**Application by Green Hill Solar Farm Limited (the Applicant) for an Order granting Development Consent for the Green Hill Solar Farm (the Proposed Development)**

**Scoping consultation and notification of the Applicant's contact details and duty to make available information to the Applicant if requested**

Milton Keynes City Council has reviewed the applicant's EIA Scoping Report (prepared by: Lanpro, dated: July 2024). Our comments relate to the Site G and the cable route search area within the Council's boundary.

Title:
Figure 8.1.5 Site Locations and Study Area
Green Hill G

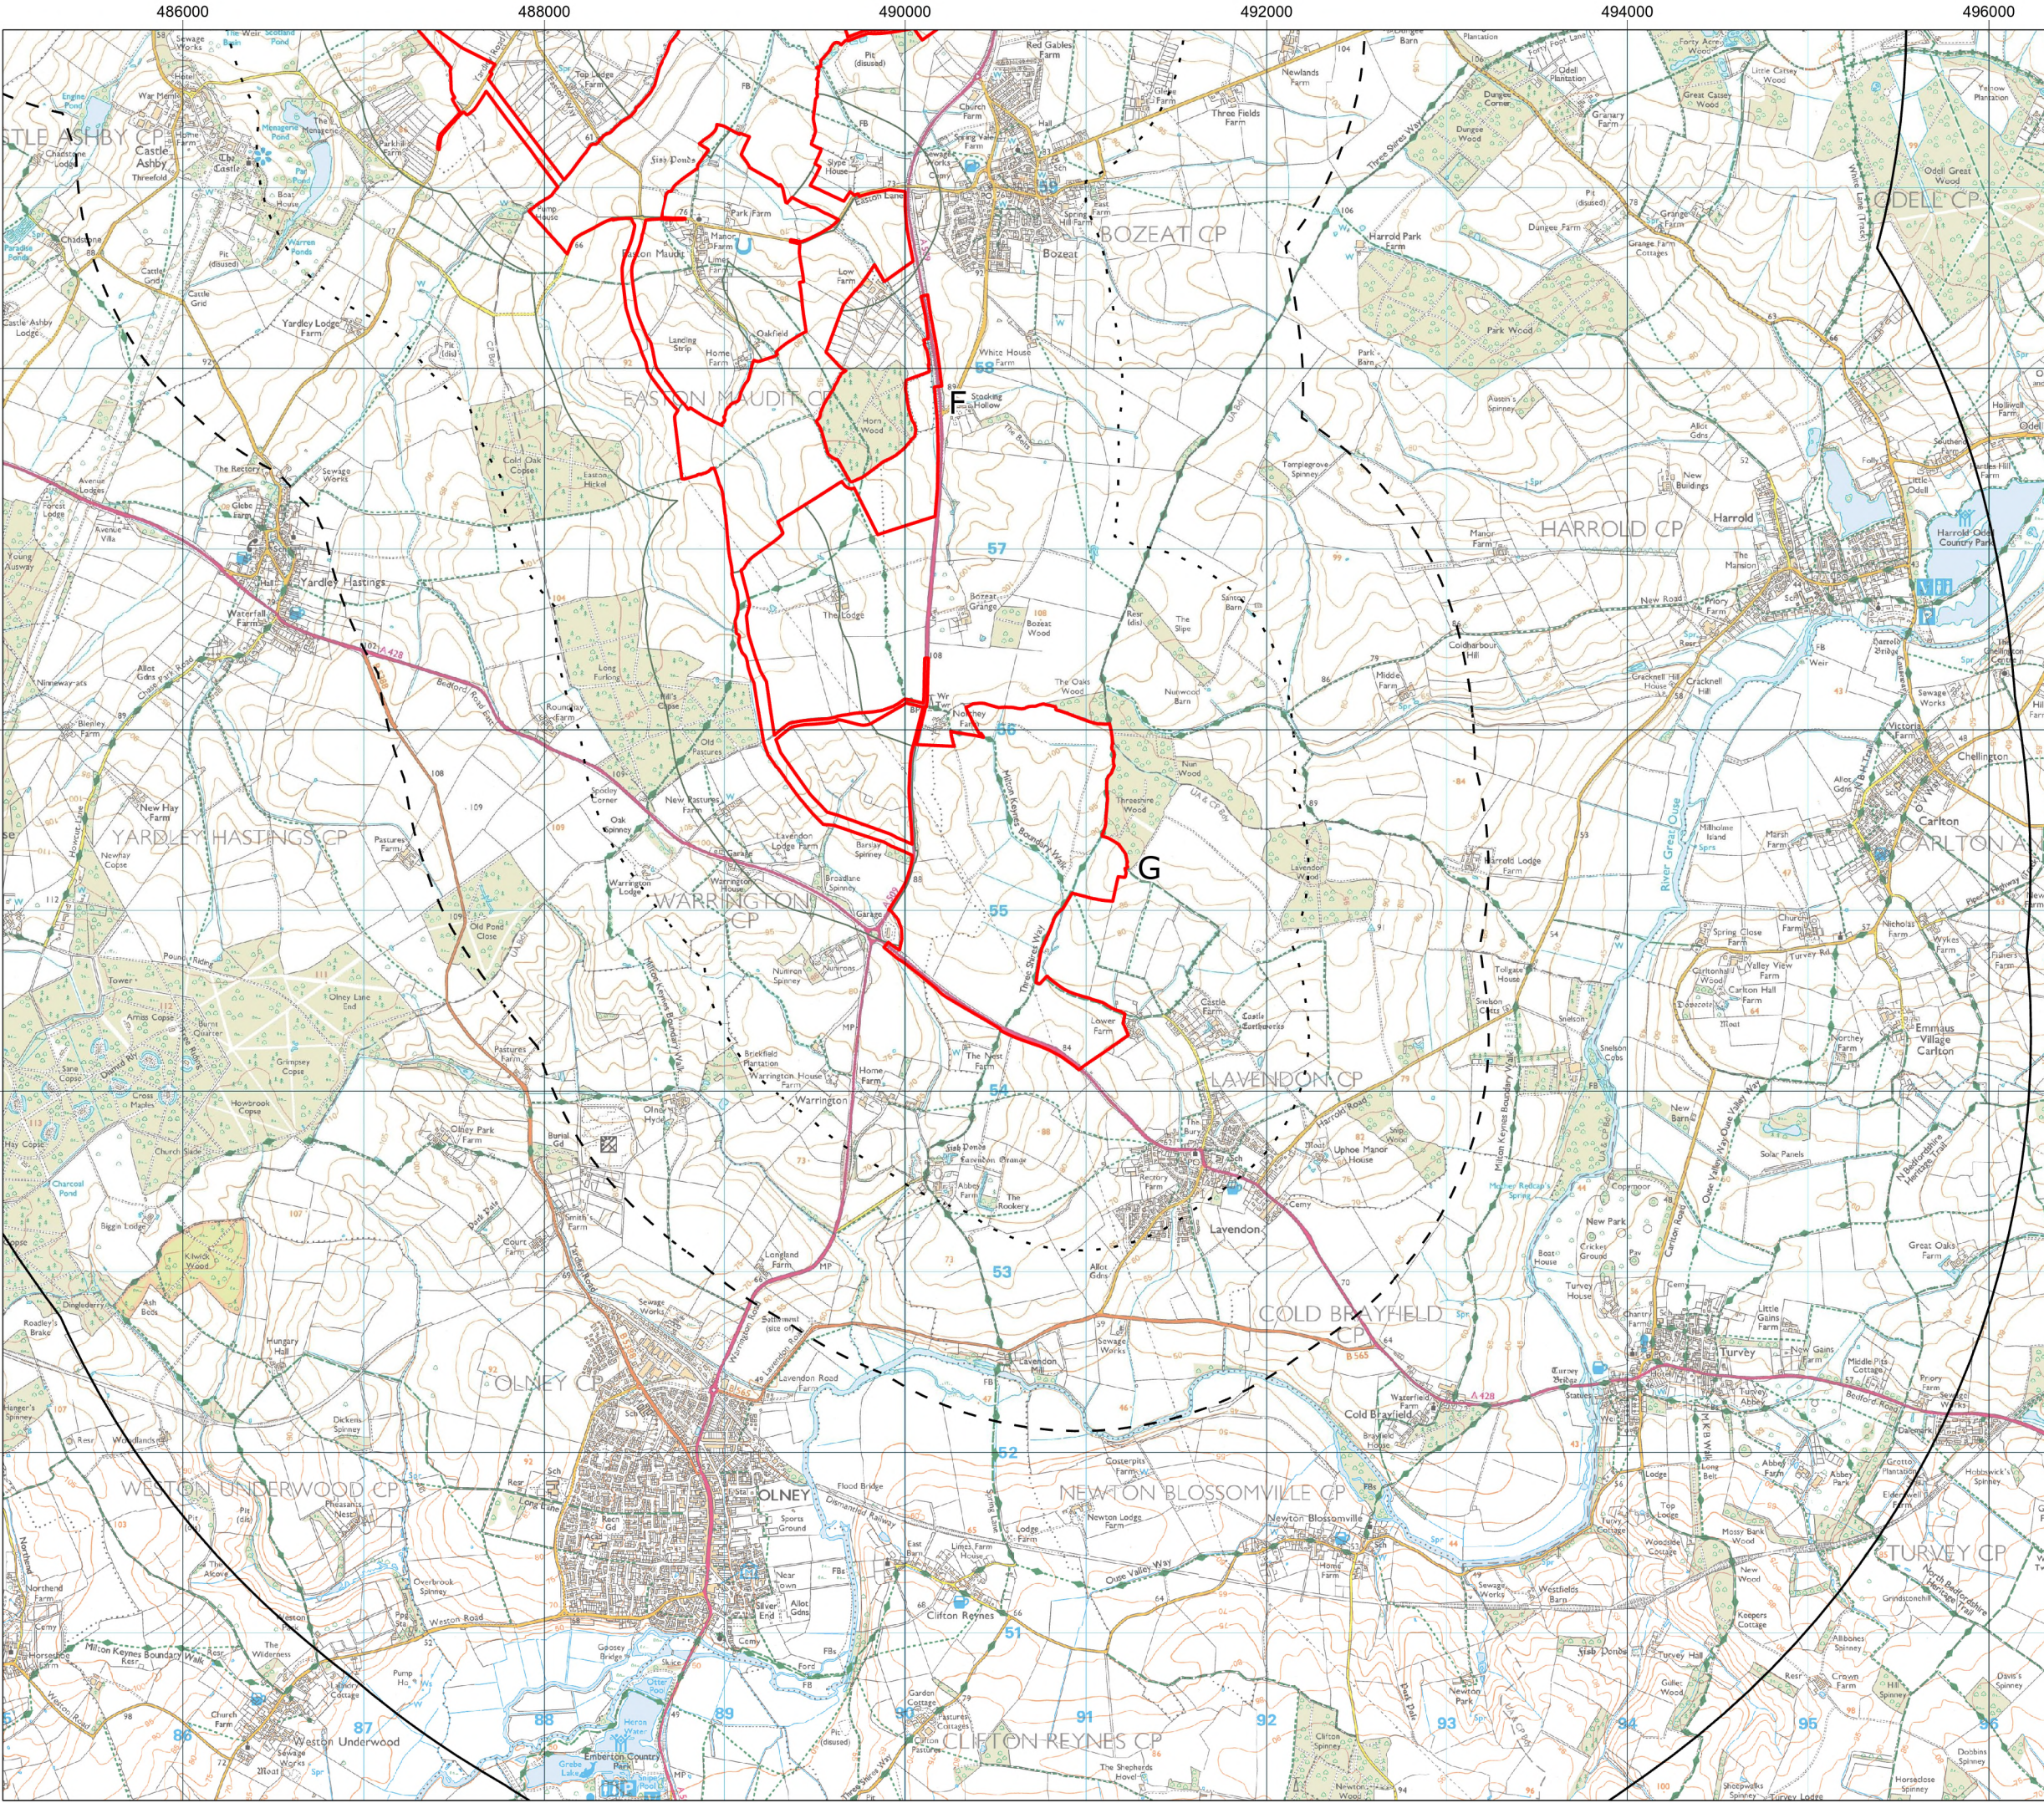
The scoping request mentions a list of viewpoints, but these are not shown on a map for consideration, the project LVIA consultants should provide the Council with proposed locations for viewpoints and photomontages on a plan with sample photographs for review by the Council's Landscape and Conservation teams.

In Milton Keynes, the GF9 and 13 field parcels east of Lavendon bridleway BW 15 are located in identified locally attractive landscape which is currently non-designated but being considered as a designation in the local plan review. Specific to this site the area would fall within the Ouse Valley Special Landscape Area, the relevant text starts from page 80 of the scoping report.
